Stormwater Management Plan (SWMP)

Super Star Car Wash – Falcon Marketplace – Lot
10

PCD Filing No.
PPR-21-008

SWMP Preparation Date: [2/9/2021](#)

NOT FOR CONSTRUCTION		
DESIGN SWK	DRAWN SWK	CHKD TOP
SCALE: H: 1" = 20' V: 1" = XXX'		
JOB No. 020441-01-001		
DATE: 02/09/2021		
SHEET C2.1

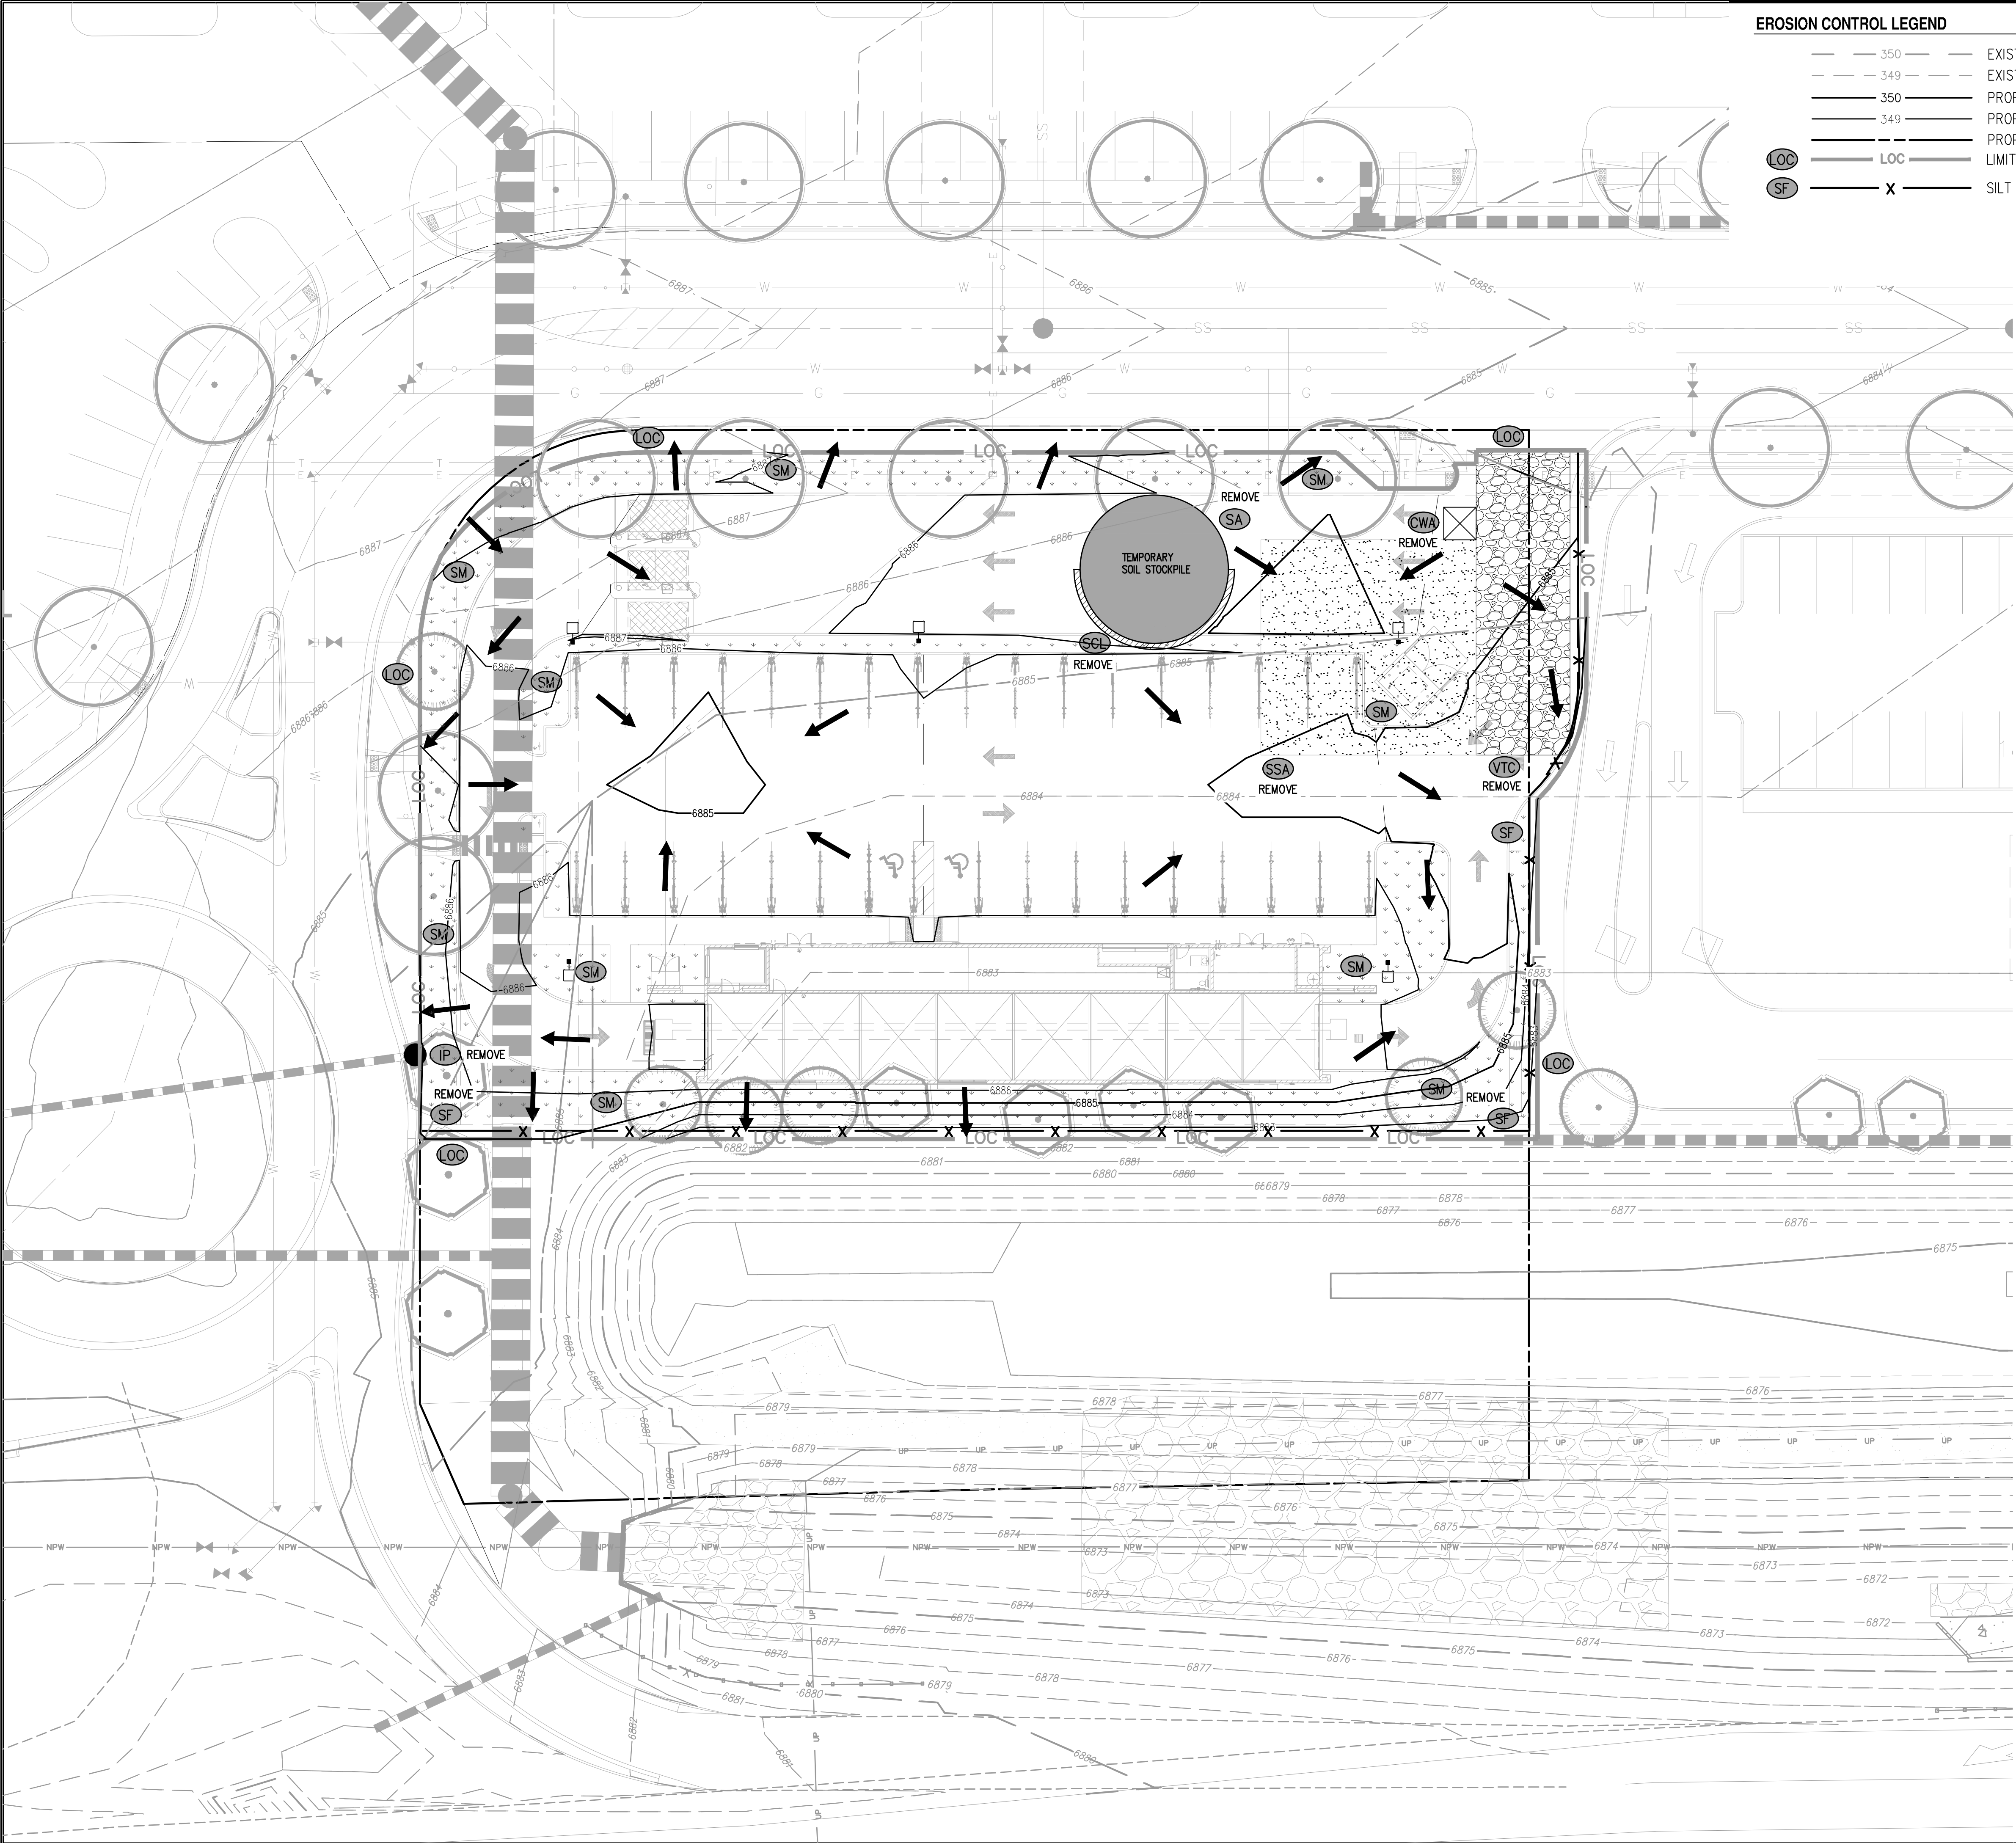
Note somewhere in this SWMP that:
The contractor will be responsible for any re-excavation of sediment and debris that collects in Pond #2 as required to ensure that the pond meets the design grades following construction. The storm lines shall also be cleaned and free of sediment once the site becomes stabilized.
